Recommendation Report for Planning Permission for Works or Extension to a Dwelling

REF NO: LU/368/19/HH

LOCATION: 3 Meadow Way  
Littlehampton  
BN17 6BW

PROPOSAL: Proposed 2-storey front extension.

Client:		Janet Dyke
Address of Works:		3 Meadow Way Littlehampton West Sussex BN17 6BW
Drawing Title:		Proposed 2 Storey Front Extension Planning Permission Issue
Paper Size:	A3	Date: Nov. 2019
Job Number:	AR-141	Drawing Number: 06 Revision: Revision

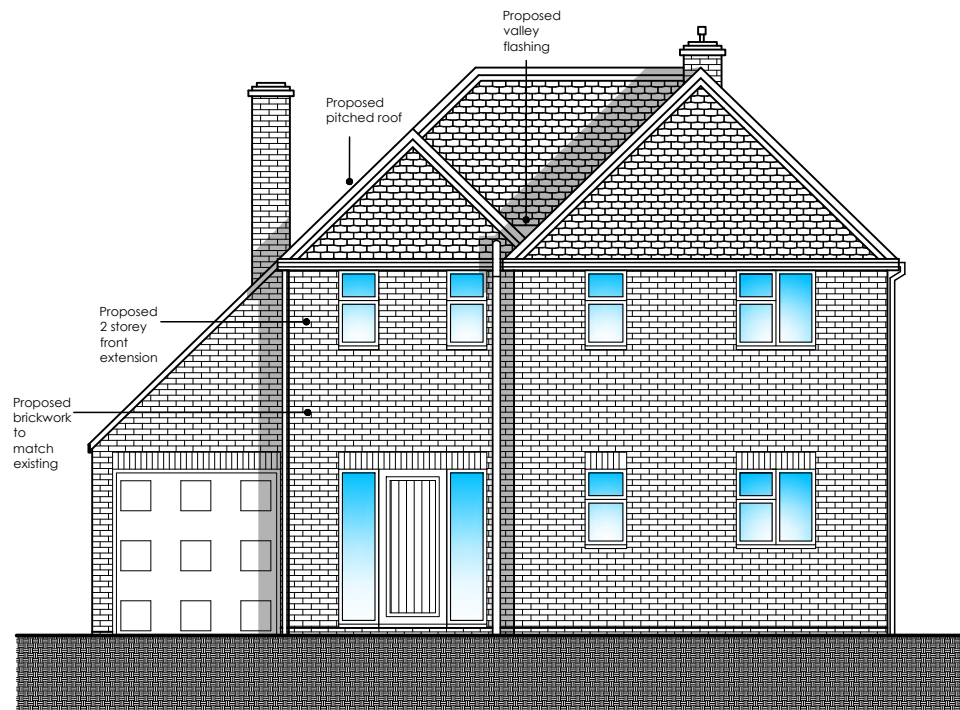
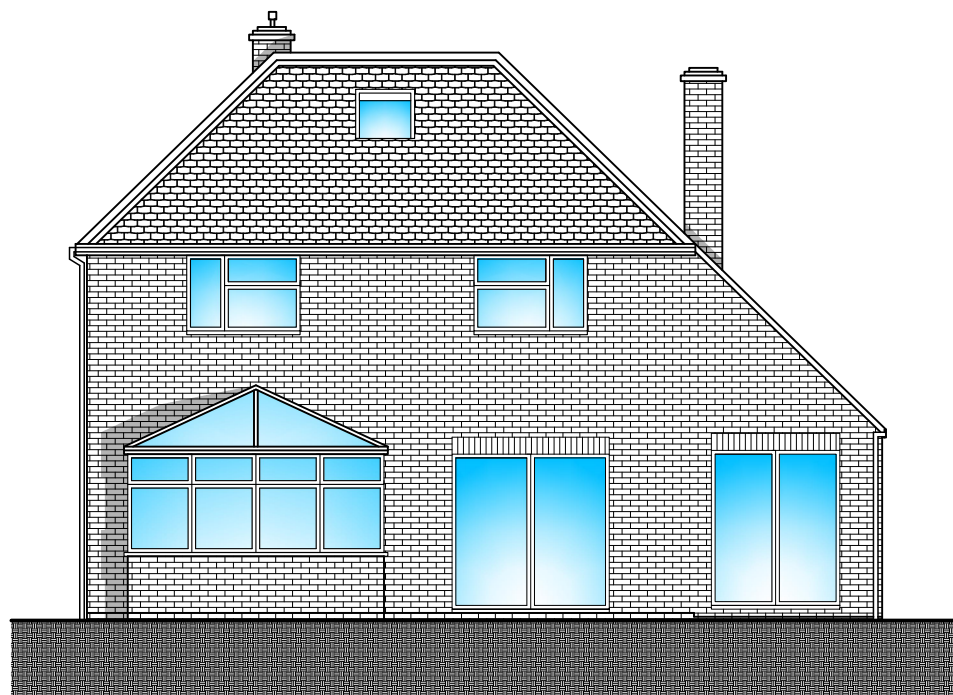
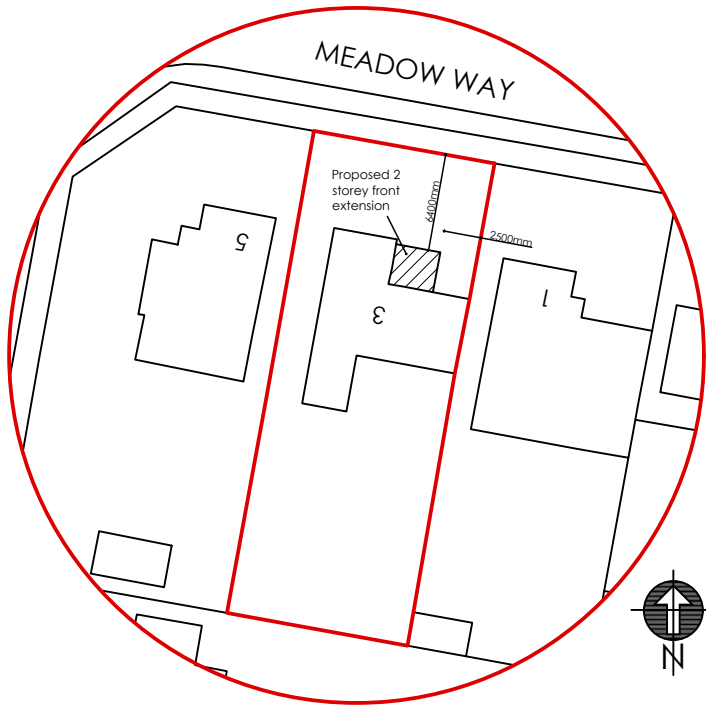
Due to the location of the proposed development being to the front of the property it is highly visible from the street scene. Whilst the proposal is considered to comprise a significant change to the appearance of the host dwelling, it is not considered to have a significantly detrimental impact on the character of the host dwelling, resultant of its modest scale. The proposal is not considered to appear as a prominent and obtrusive within the locality, as a result of its design appearing sympathetic to the host dwelling, the fact that the area is host to a many varying design and scales of dwellings. The proposed development is considered to be in accordance with D DM1 and D DM4(a) of the Arun Local Plan.

The proposed front extension will have a width of 2.98m, a depth of 2.765m, with an eaves height to match that of the existing two storey element of the dwellinghouse at 5.25m and a proposed pitch height of 6.85m. As such the proposed development is considered to be in accordance with D DM1, D DM4(b) and (e) of the Arun Local Plan.

PROPOSED EAST ELEVATION 1:100

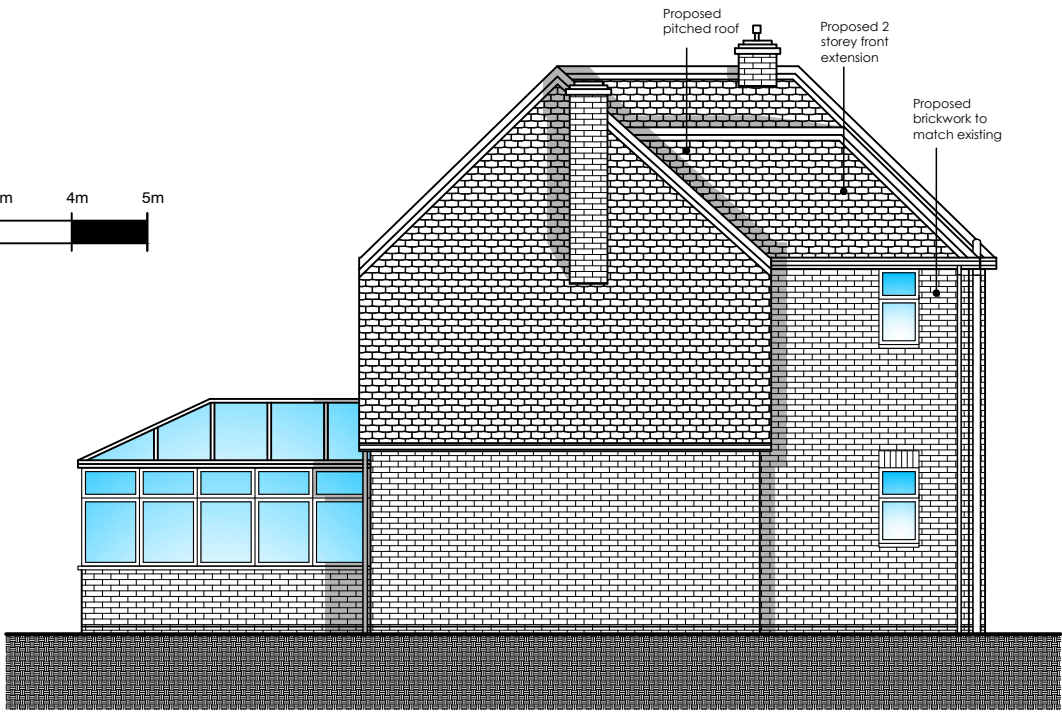
One letter of objection due to fears of overlooking and loss of privacy. Request for a minimum of the 1st Floor window on the Eastern elevation to be obscure glazed.

The proposed development is not considered to have any significantly harmful impact upon the residential amenities of neighbouring dwellings, by way of overshadowing or overbearing. This is as a result of its scale, siting and the aspect of the development. The proposed development is not deemed to result in a loss of privacy to occupiers of neighbouring dwellings, as it features only two openings at first floor level facing the street scene nor more projecting forward than current first floor openings and a small window that looks into a neighbouring wall with little to no views into the neighbouring property. The other openings are at ground floor level, and therefore, provide no views currently unavailable from the garden as current.
